**Our Ref: FP/114/11/CA**  
**Your Ref:**

**Please ask for:**  
Mrs S Honney-Bayes  
01903 737500 Ext 37445  
14th June 2011

**Application for conservation area consent for demolition of existing dwelling & outbuildings & erection of 6 no. apartments with associated parking & landscaping (re-submission following FP/183/10/CA)**  
**30 Limmer Lane Felpham Bognor Regis**

Client	John Owen		
Job	30 Limmer Lane Felpham, Bognor Regis, West Sussex.		
Drawing	Proposed Apartments Proposed Elevations		
Date	August 2010	Scale	1:50@A1 1:100@A3
Drawn By	L.O.	Dwg. No.	030510/SL-32A

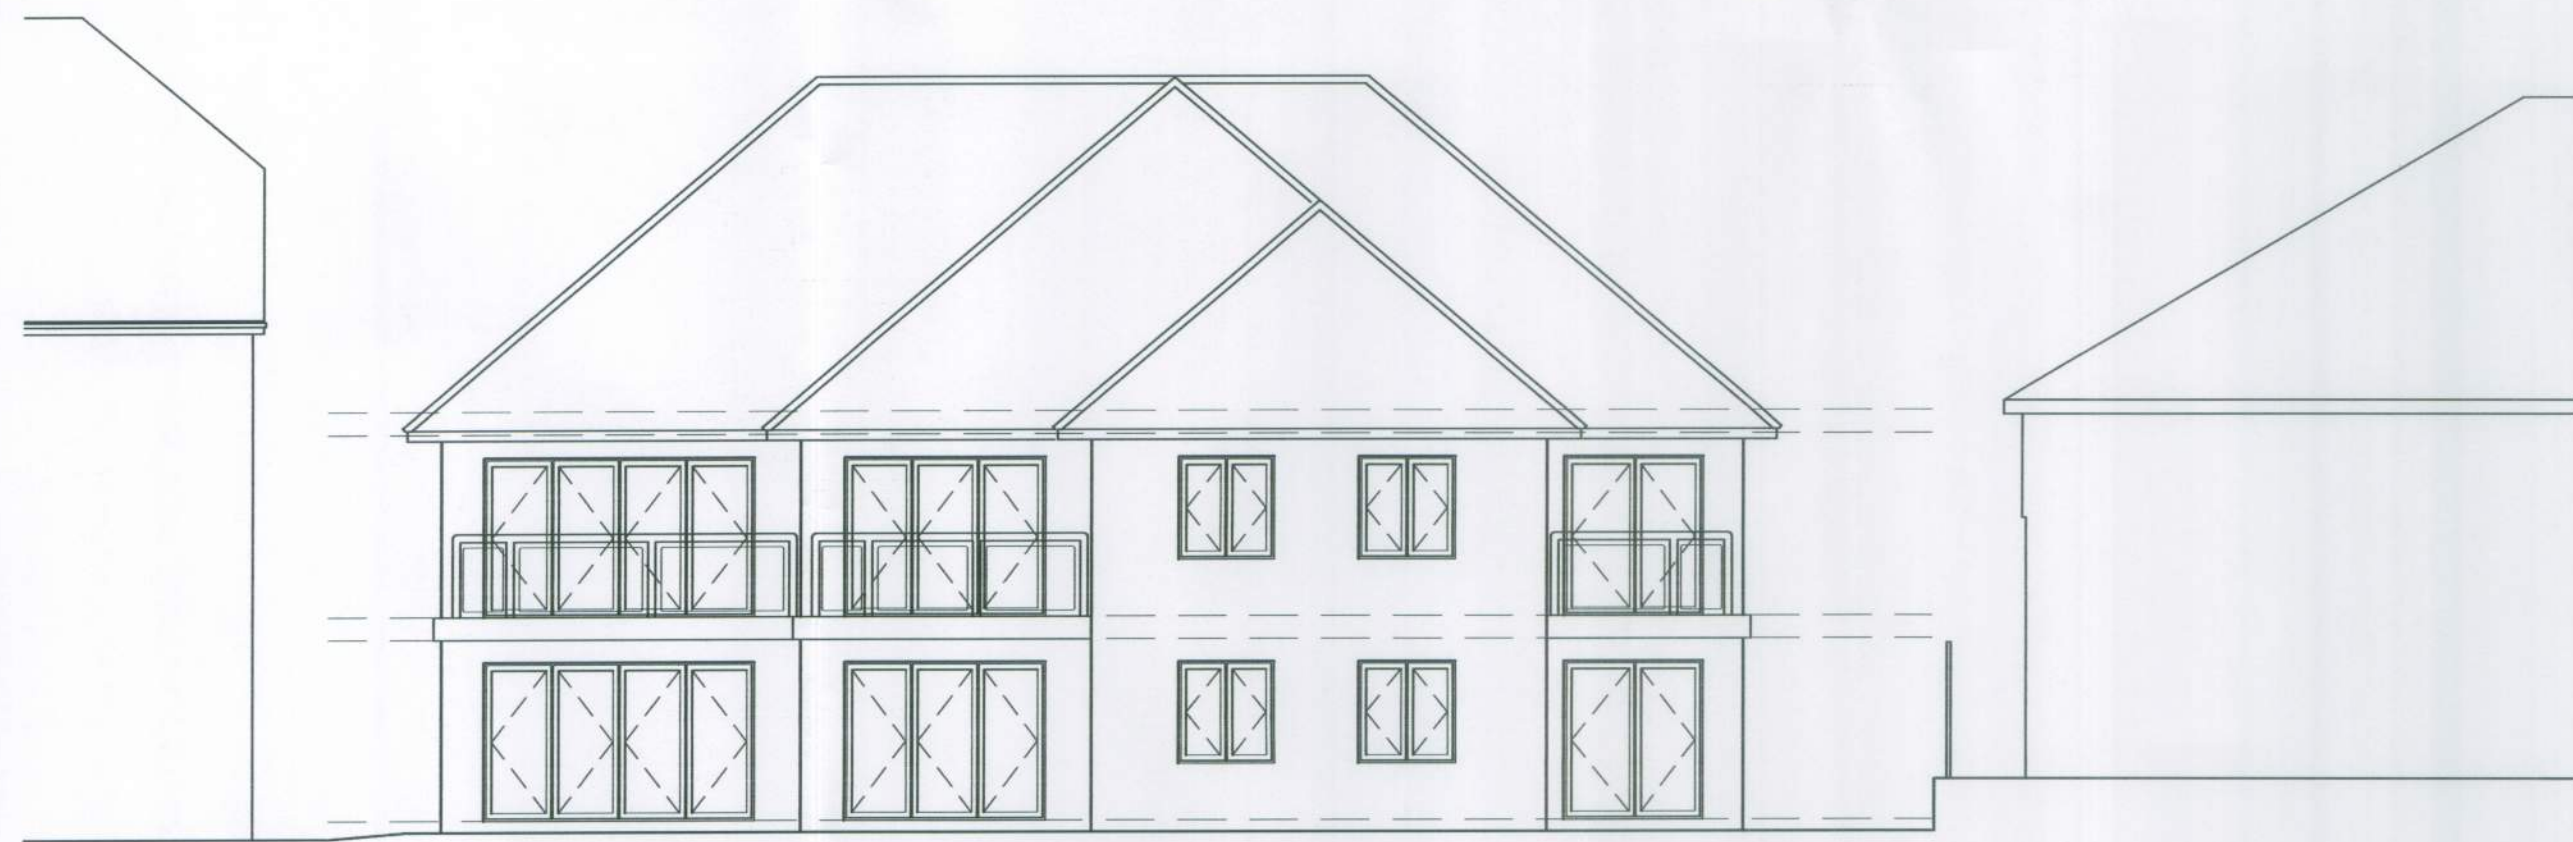
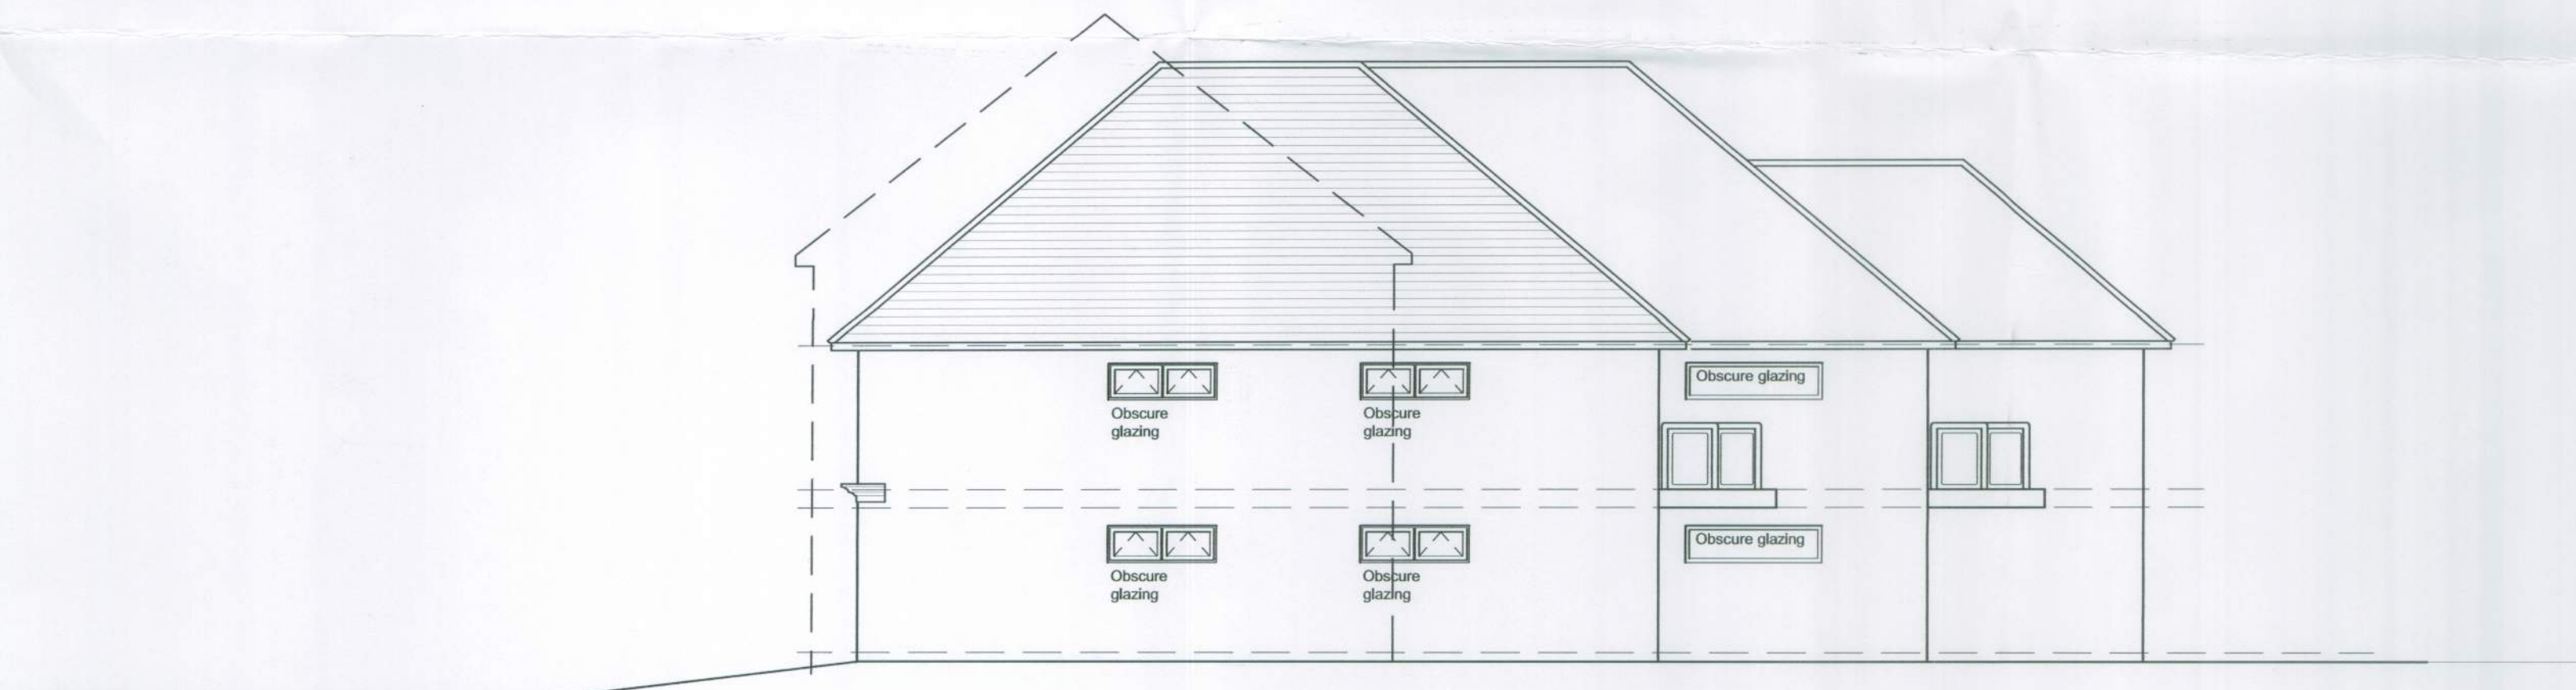
Please provide 1 electronic or 3 paper copies of existing elevations and proposed side and rear elevations in accordance with the guidance notes available on our website detailed below (click on National List).

Drawn By **L.O.** Dwg. No. **030510/SL-28 - B**

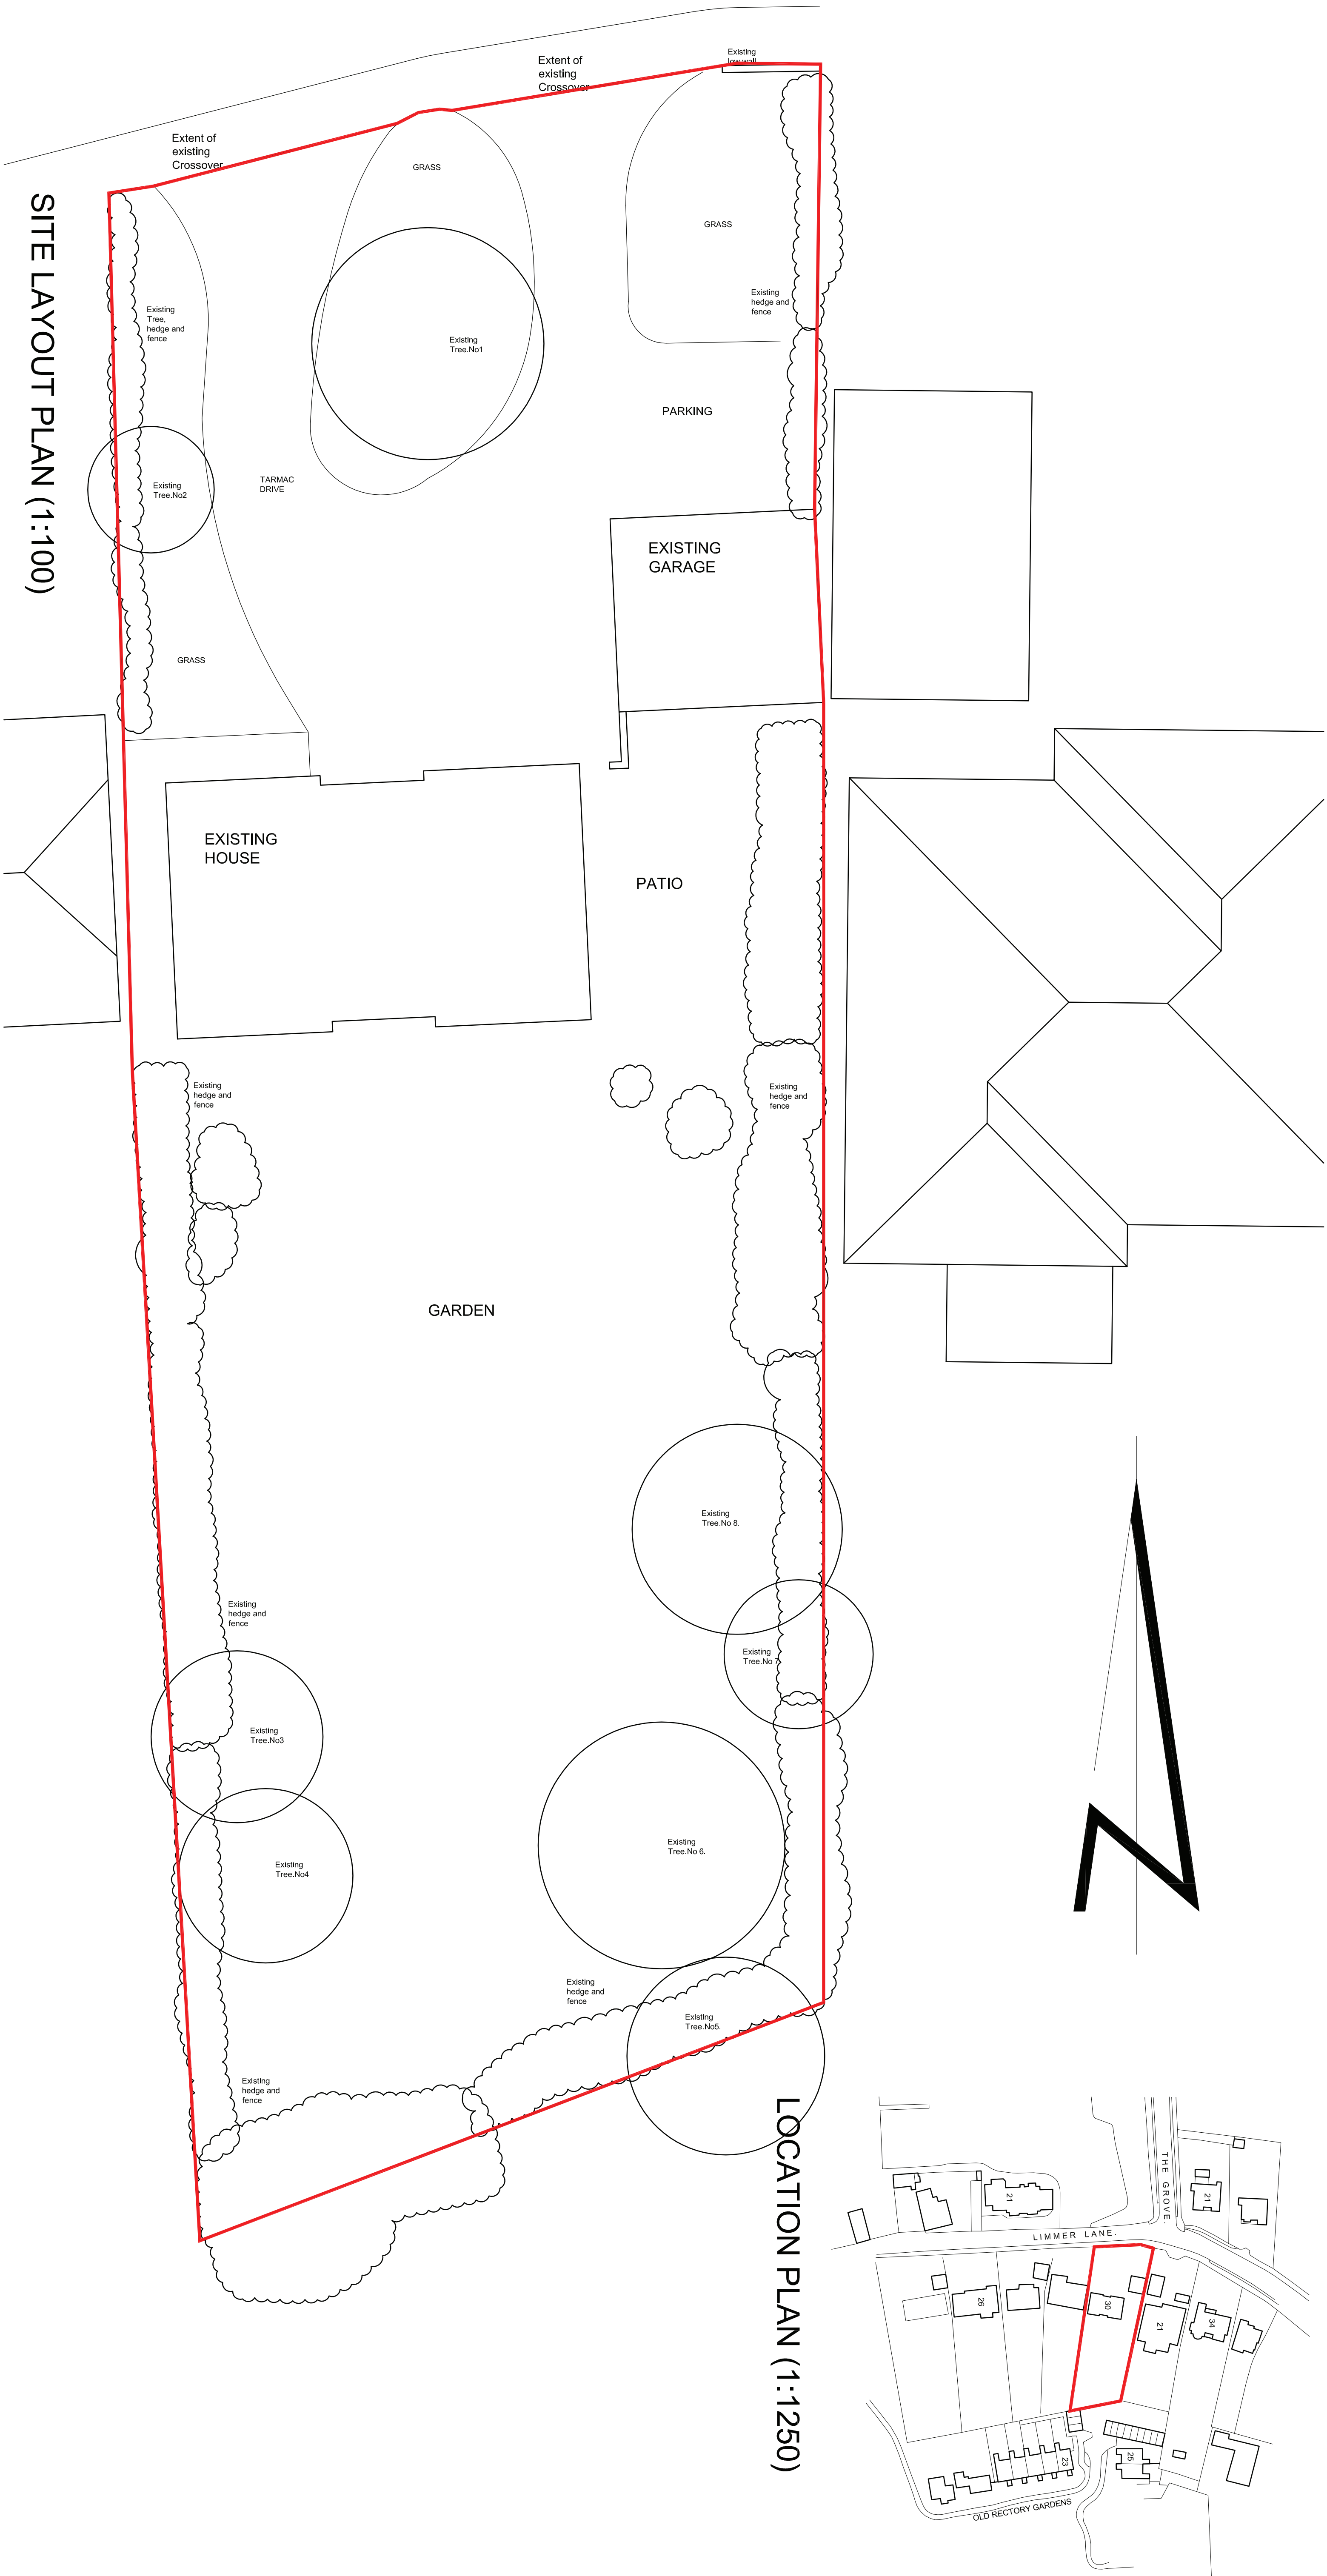
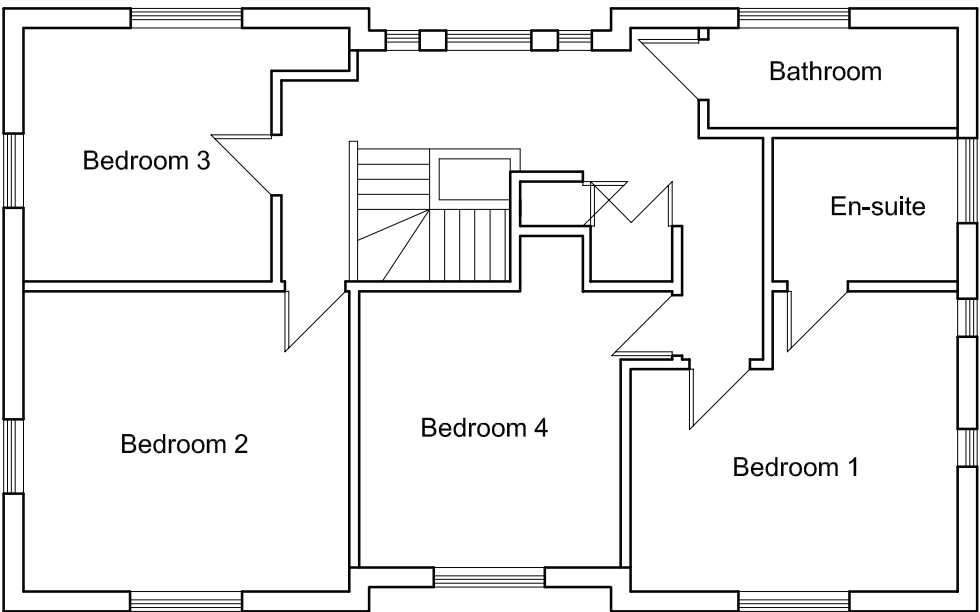
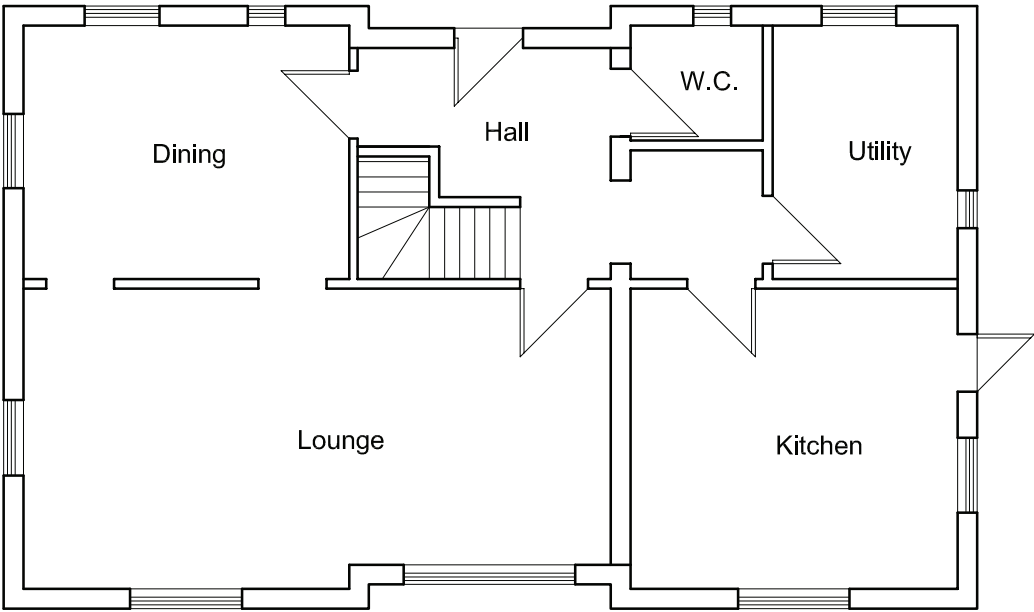
I require 1 electronic or 3 paper copies of a revised existing block/site plan showing a red edge around the application site, and a revised proposed block/site plan showing the 6 cycle spaces, in accordance with the guidance notes available on our website detailed below (click on National List).

I require 1 electronic or 3 paper copies of a revised location plan showing a red edge around the application site, in accordance with the guidance notes available on our website detailed below (click on National List).
